**RE: Nuevo Atrisco
7901 Central Ave NW
Traffic Circulation Layout Review Comments**

The following are the responses to your comments for Building Permit TCL review for the Nuevo Atrisco project at Central & Unser dated 05/25/23.

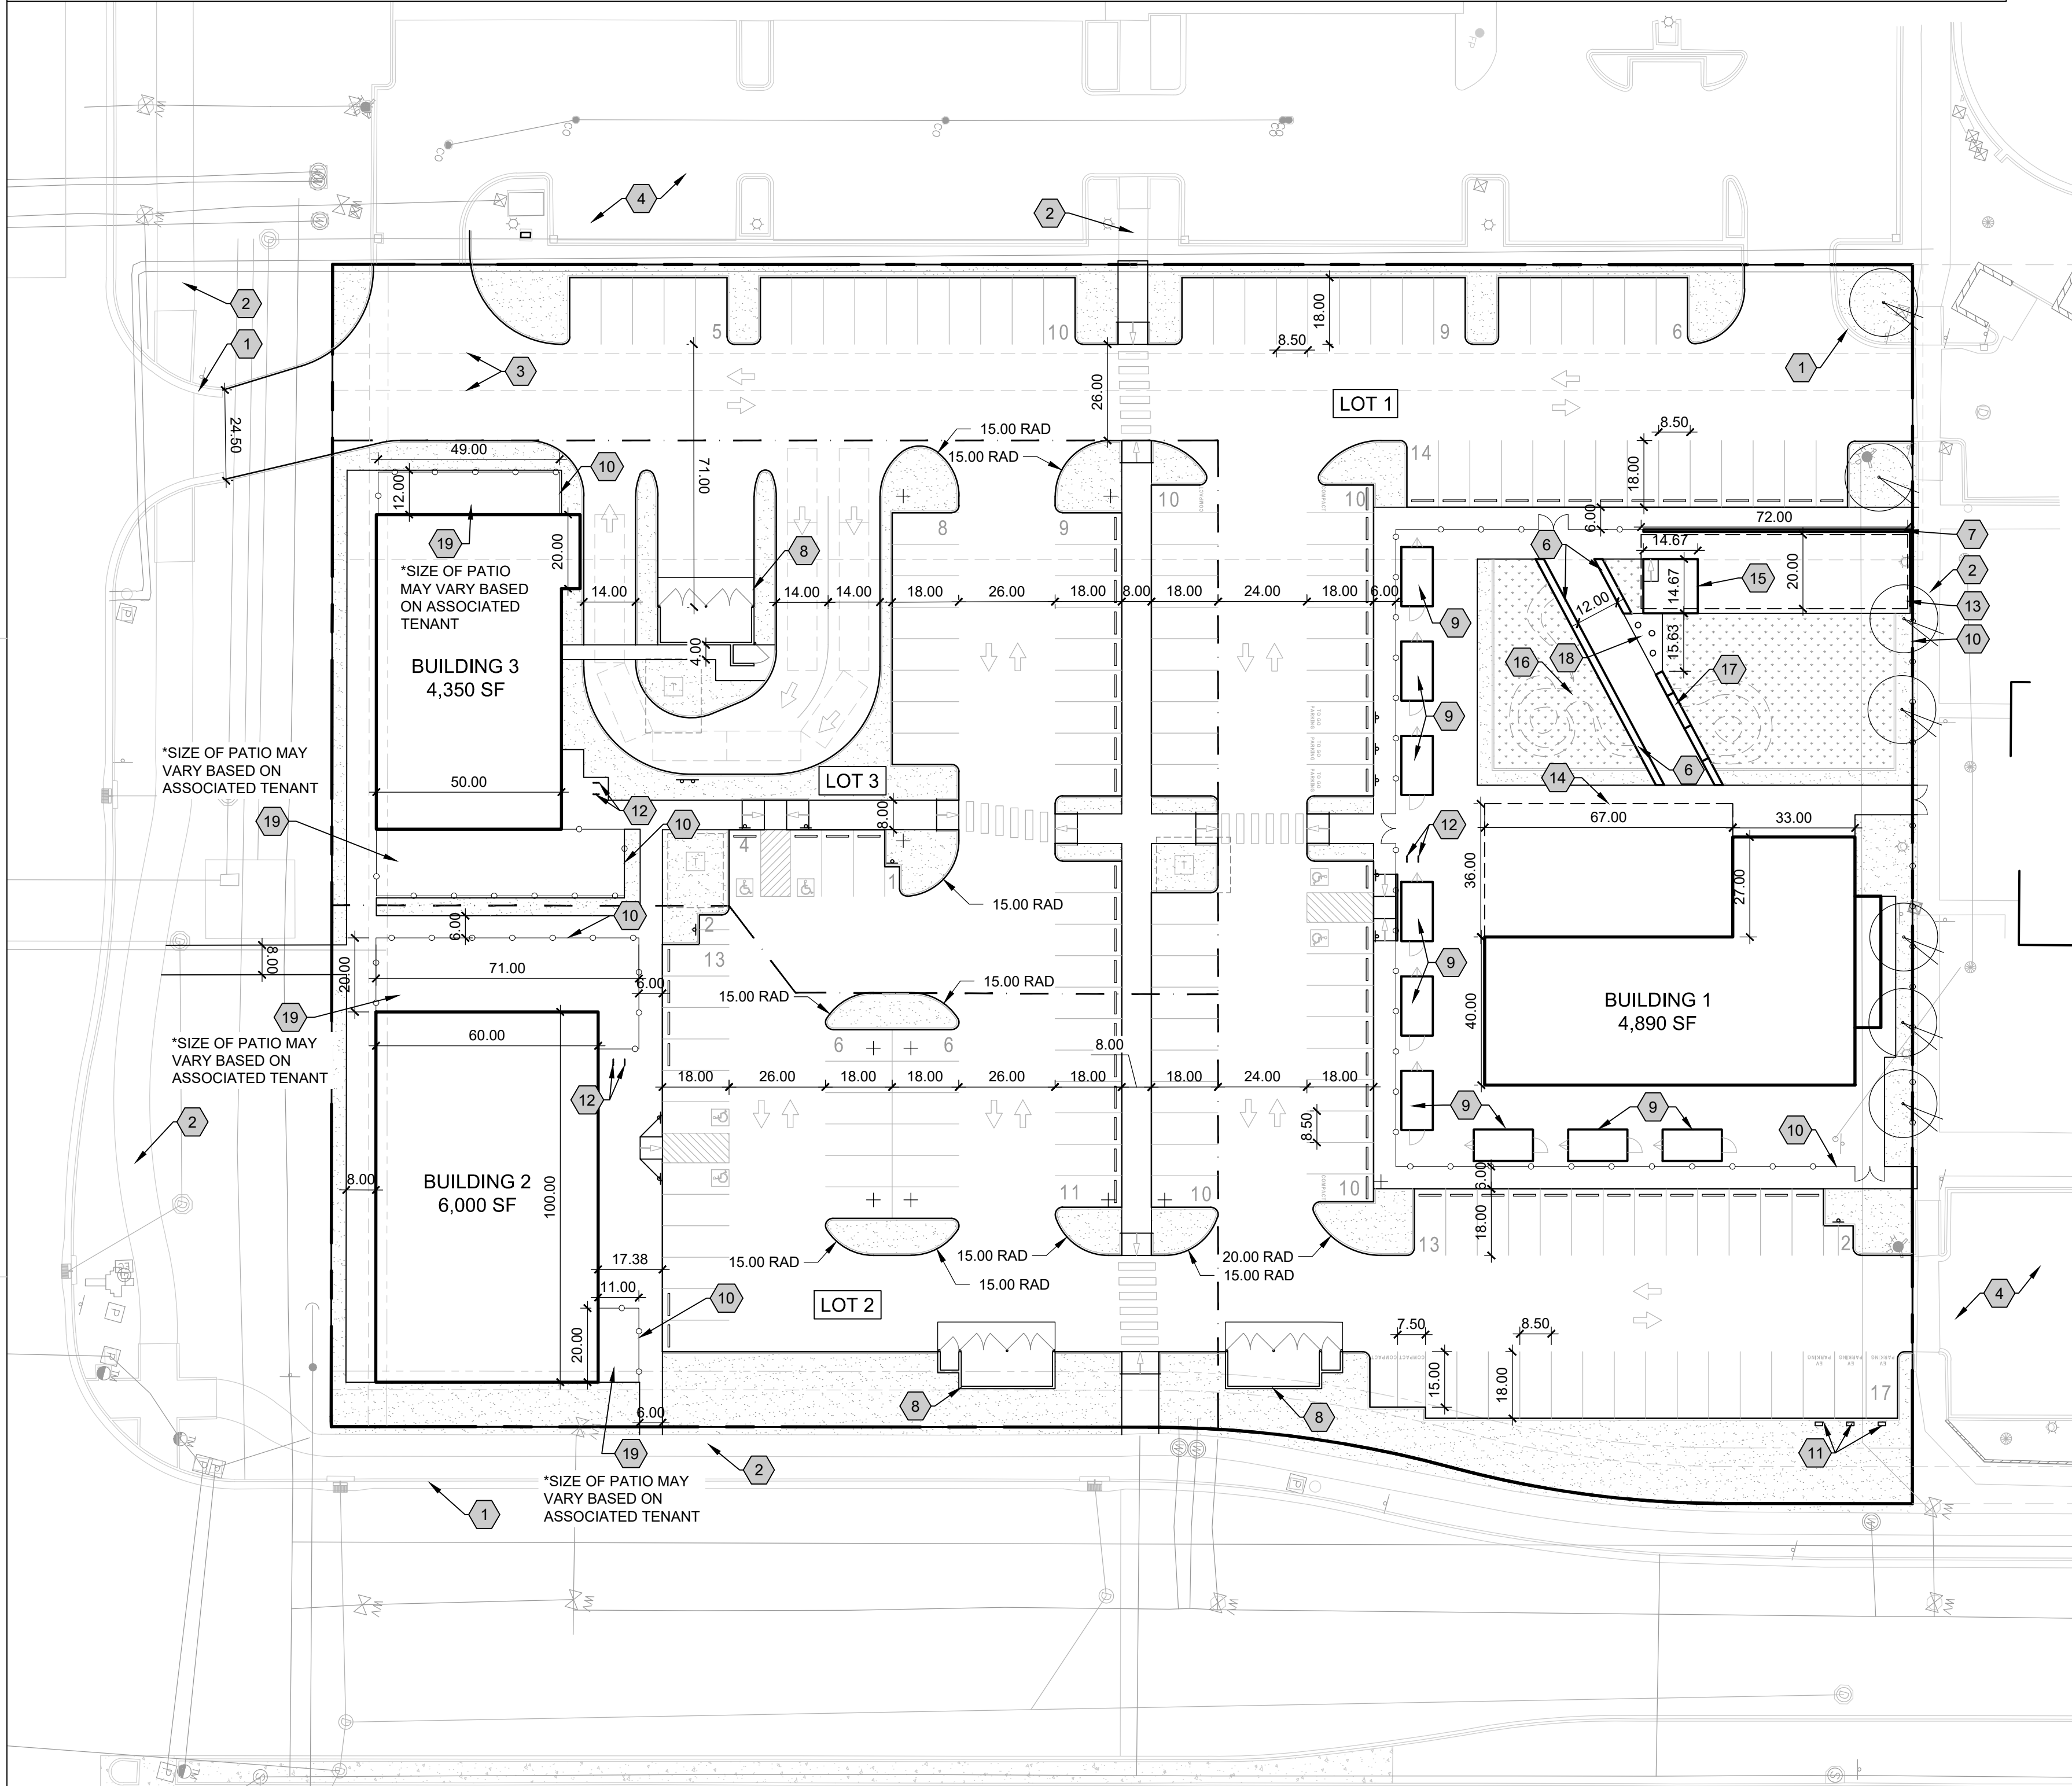
1. Vicinity map added to TCL sheet.
2. Engineer stamp and date added to TCL sheet.
3. R/W and F-F dimensions added to TCL sheet.
4. ADA Sign detail provided on Architectural detail sheet. Note added to ADA Parking detail on the paving detail sheet.

5. "NO PARKING" added to ADA Parking detail on the paving detail sheet.
6. "MC" added to motorcycle parking stalls on TCL sheet.
7. Added keyed note 13 in Phase 2. Bike Rack detail added to paving detail sheet.

8. See response 7.
9. See response 7.
10. See response 7.
11. Clear sight triangle added to TCL sheet. Keyed note 16 and General Note I.
12. Solid Waste and Fire 1 approvals are provided as separate PDFs.
